**New Request for Advice - Padstow Resource Recovery Facility (SSD-10450)  
(Canterbury-Bankstown)**

Thank you for your correspondence via the Major Projects Portal (ref: PAE-2832) dated 17 April 2020 requesting Transport for NSW (TfNSW) provide input to the Secretary's Environmental Assessment Requirements (SEARs) for the subject proposed State Significant Development.

PROPOSED SITE PLAN

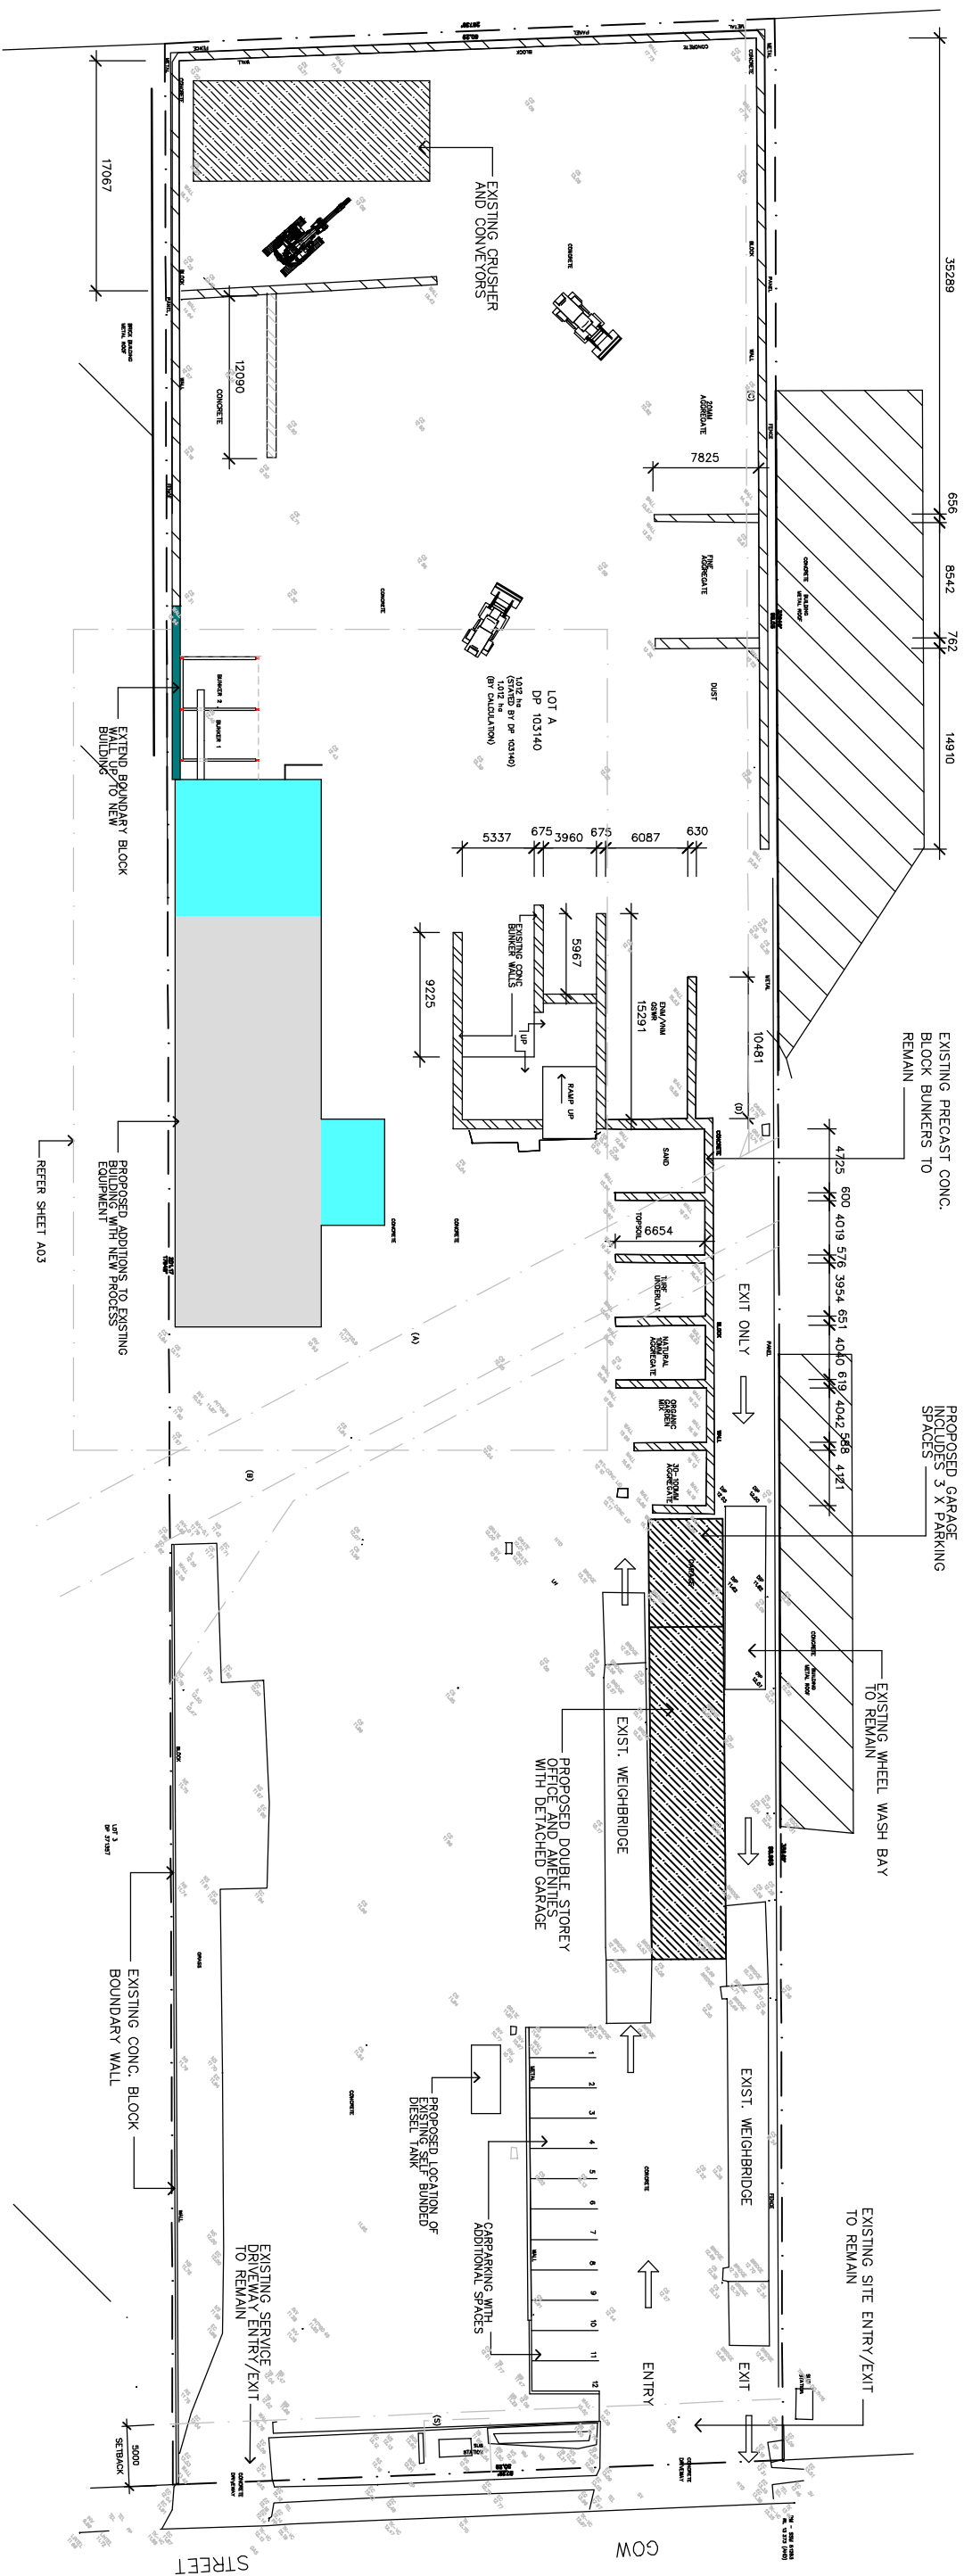
- c. Site plan showing the proposed layout of the processing plant, storage and handling facilities and truck circulation layout that demonstrates the site will accommodate the most productive vehicle types (noting that the surrounding road network accommodates 25/26 metre B-doubles);

RIGID TRUCK QUEUING PLAN

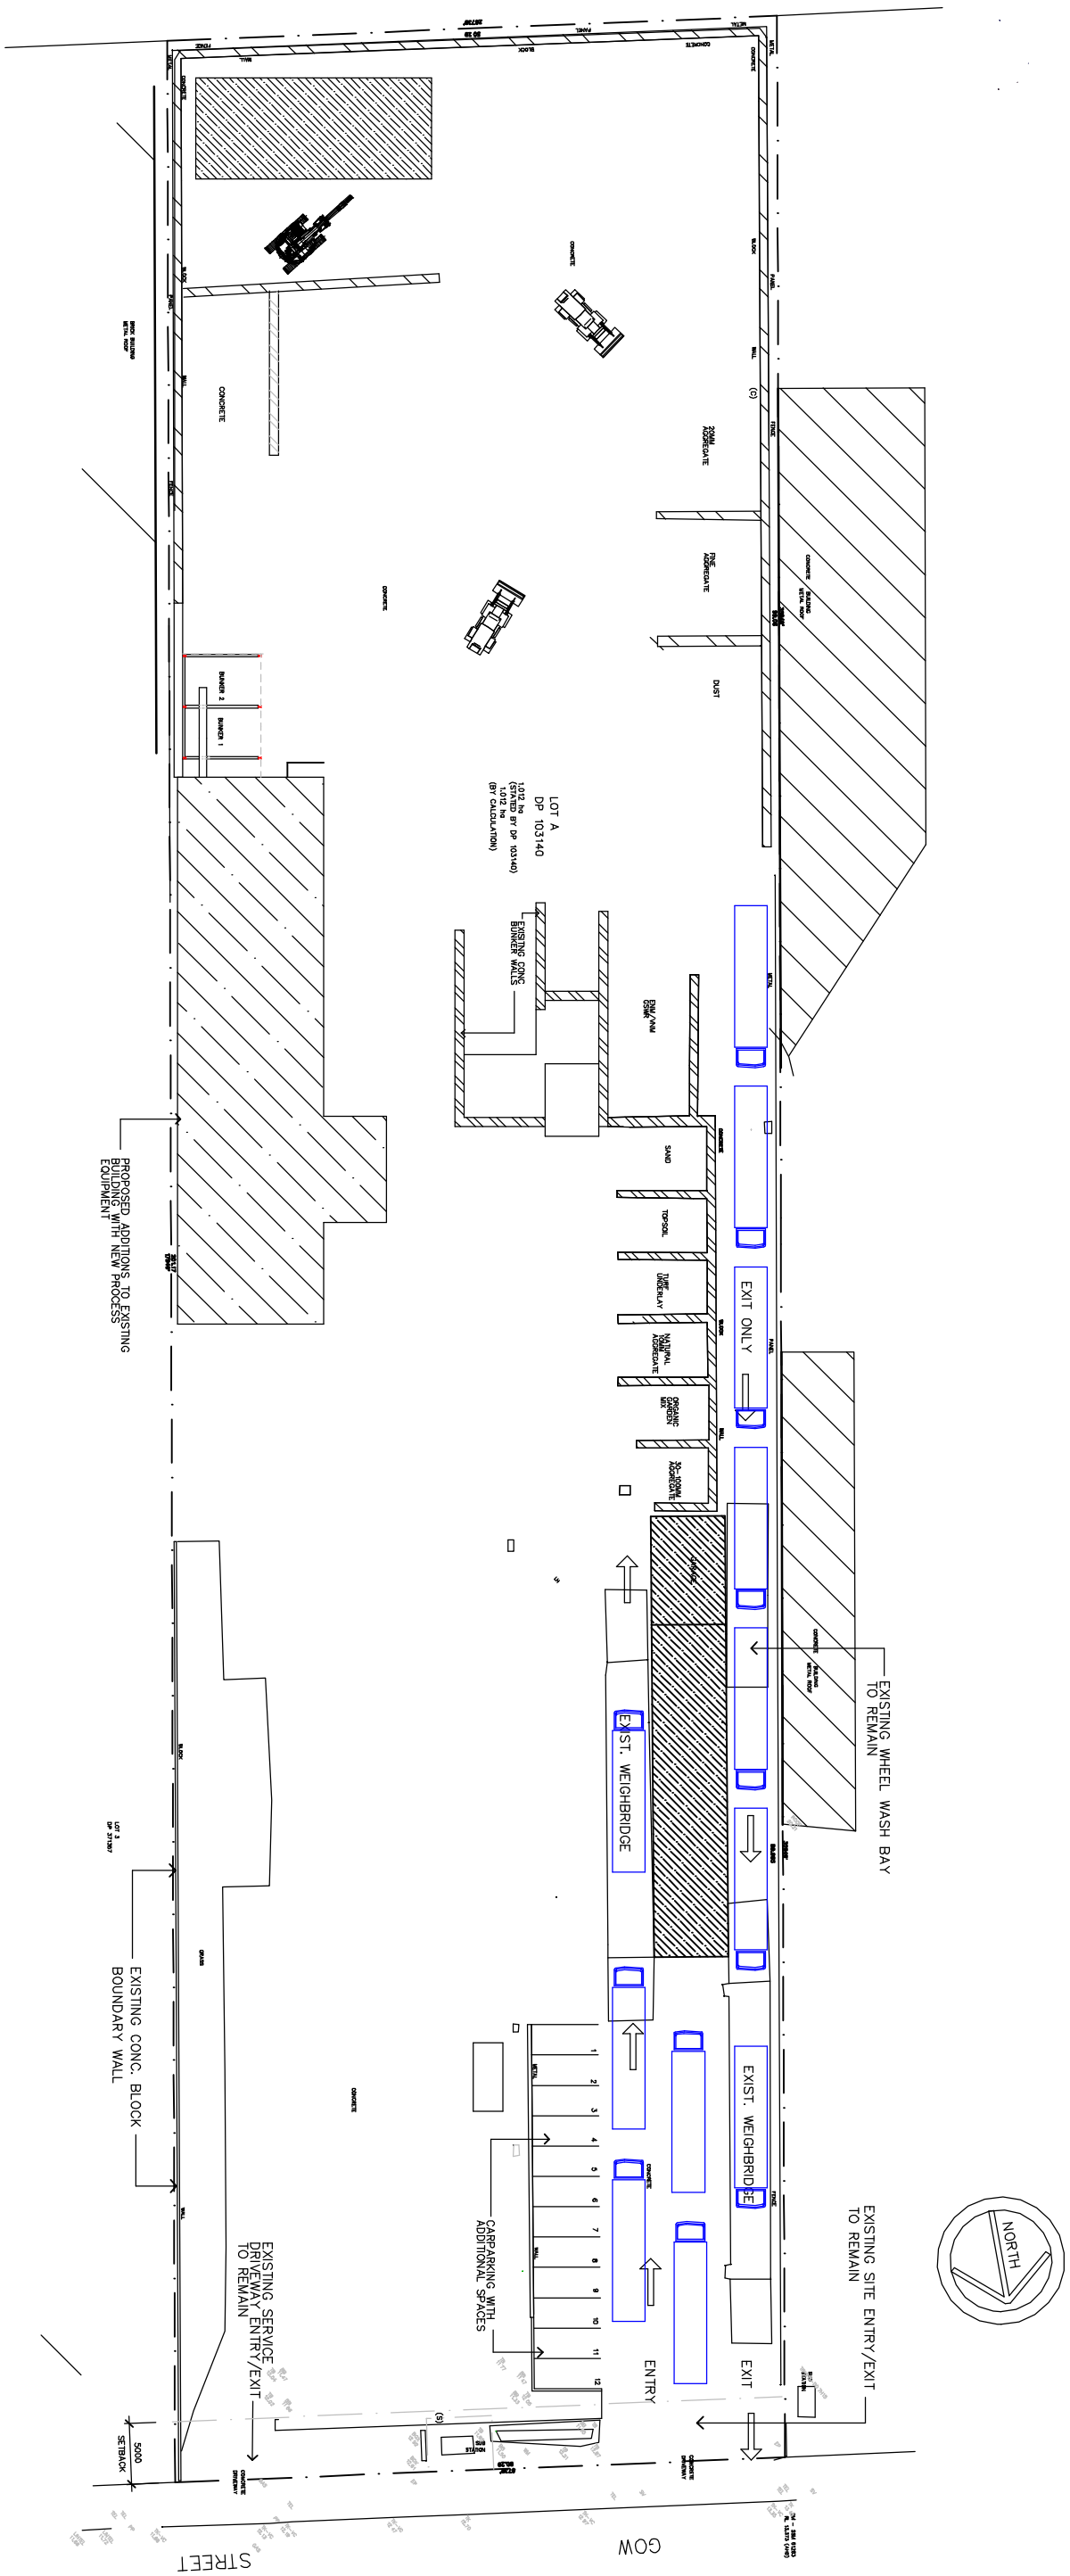
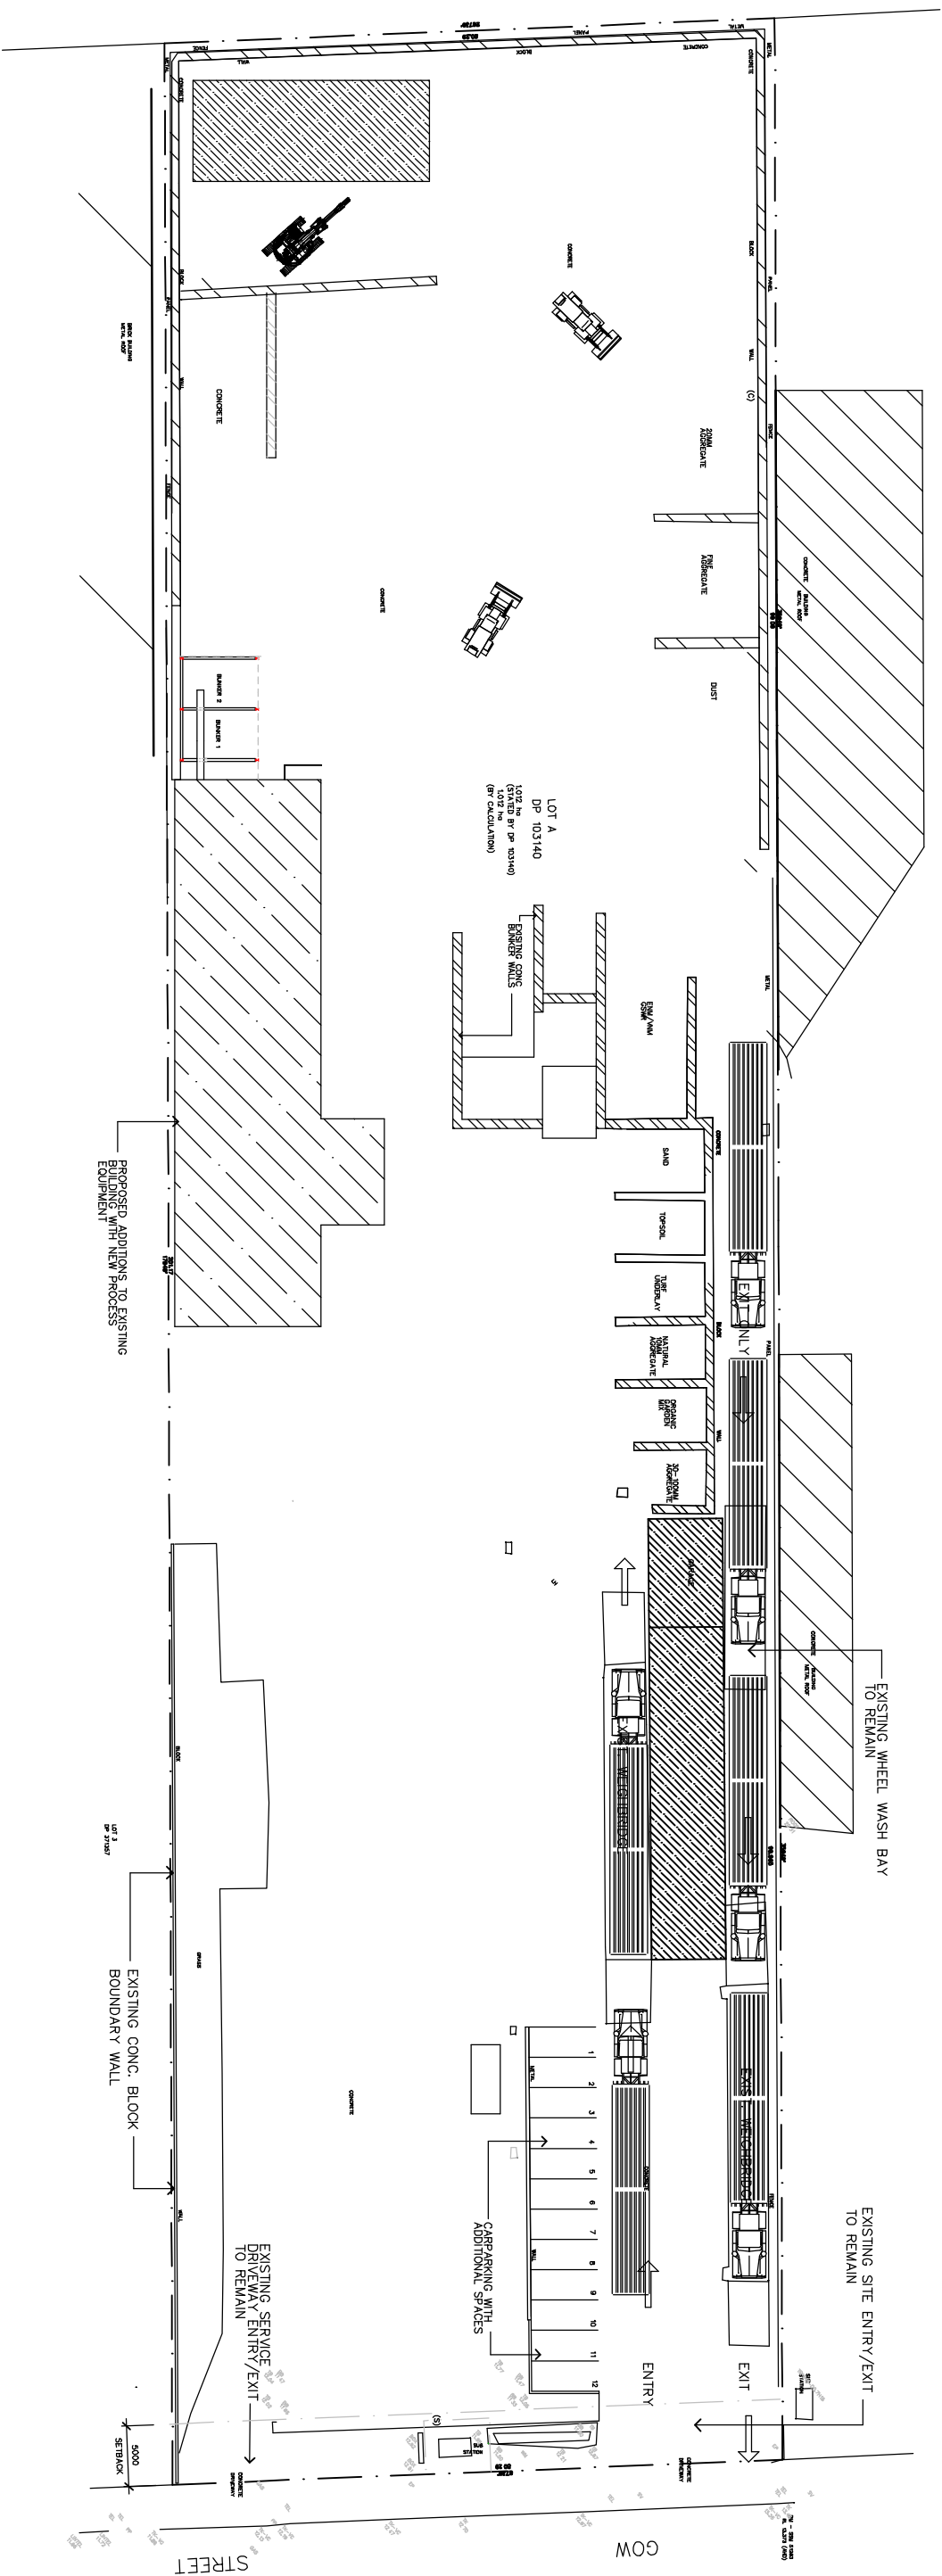
- a. An inbound and outbound vehicle profile by time of day and day of week (if travel patterns differ across the week);
  - b. Site plan and operating plan to demonstrate that the site will be managed such that queues do not develop on Gow Street;

TRUCK LOADING, UNLOADING AND WAITING PLAN

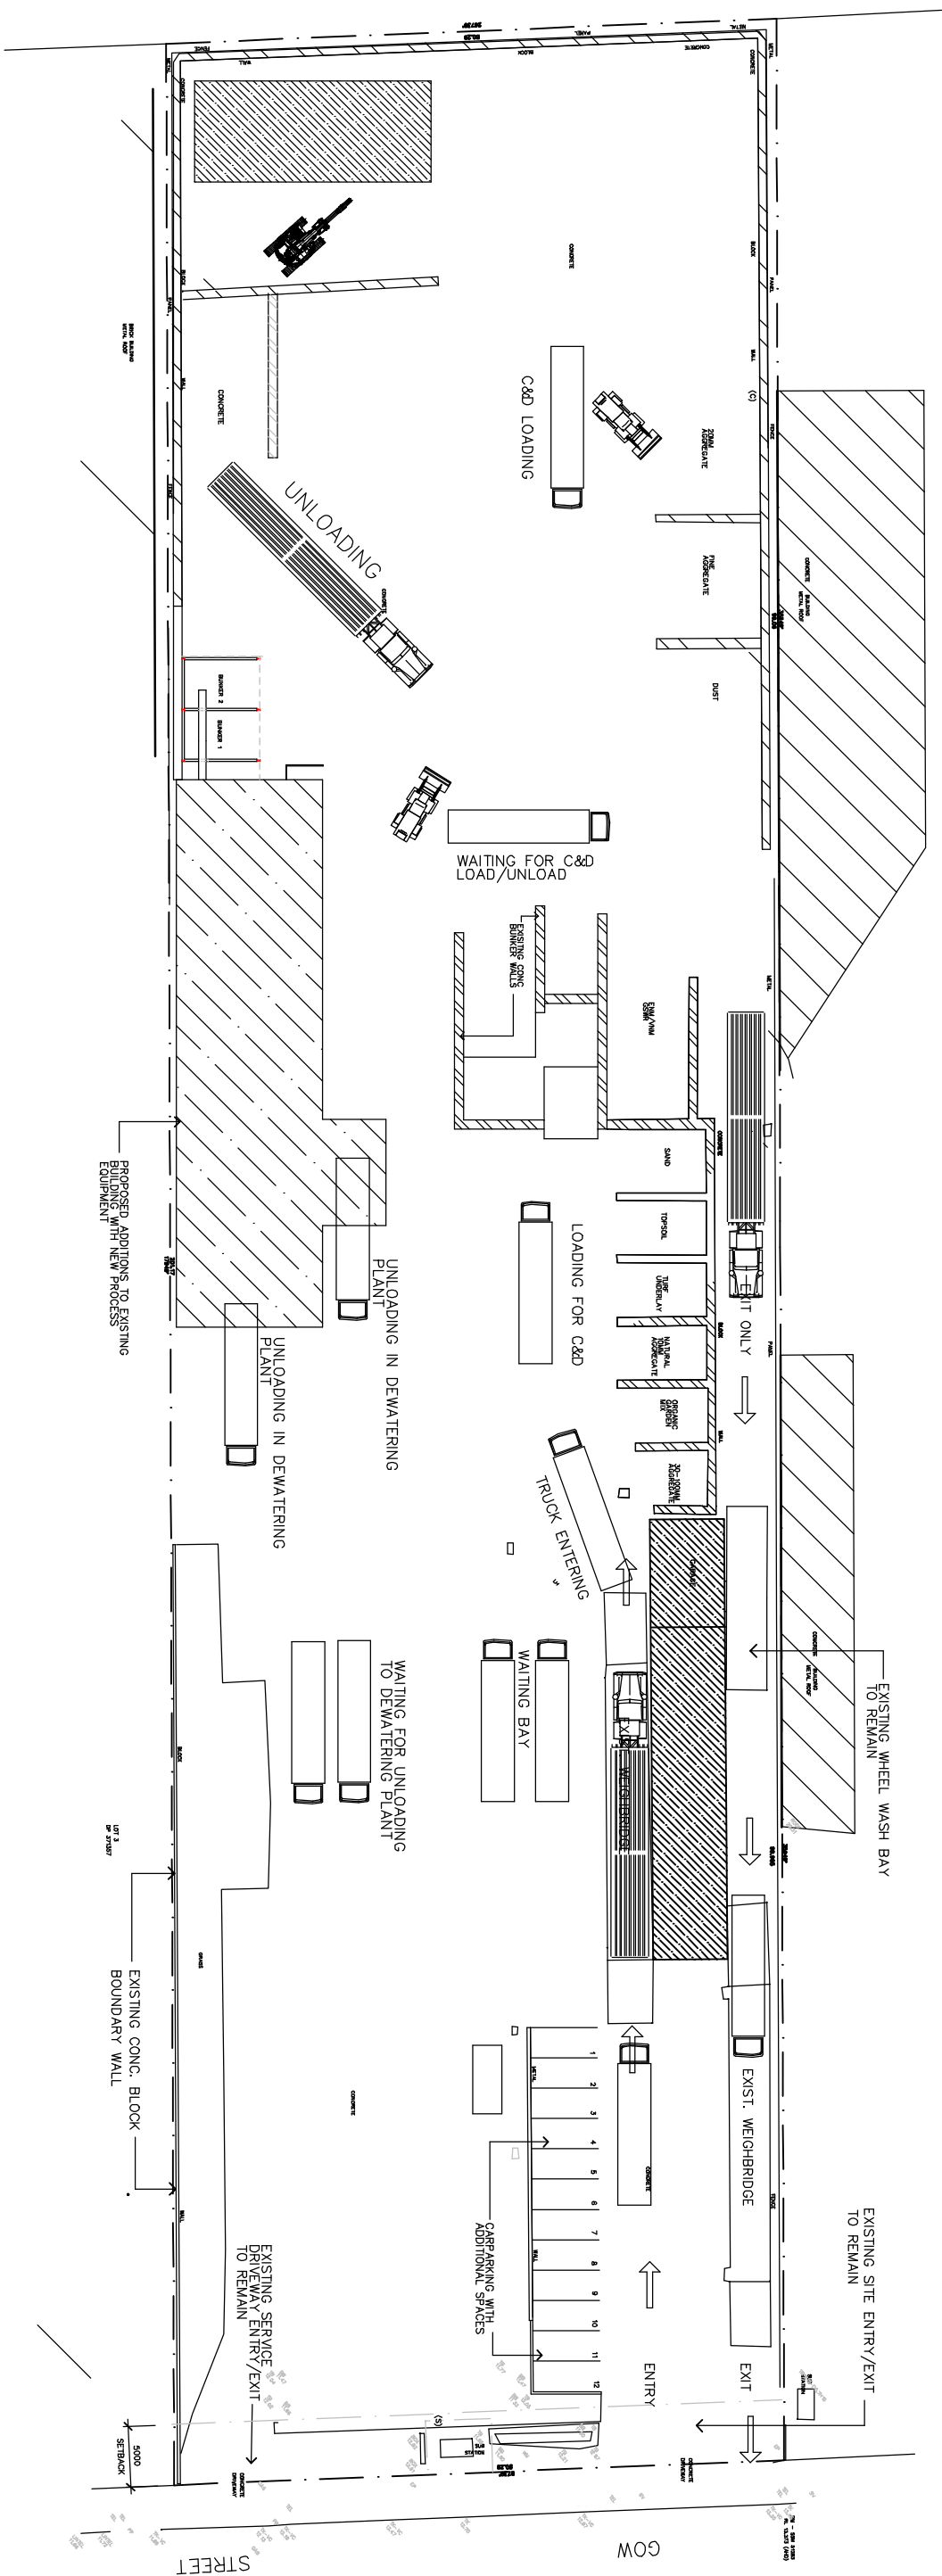
- d. Site layout that illustrates how loading and unloading (including waiting areas) will occur in relation to covered and uncovered areas for the different material types;
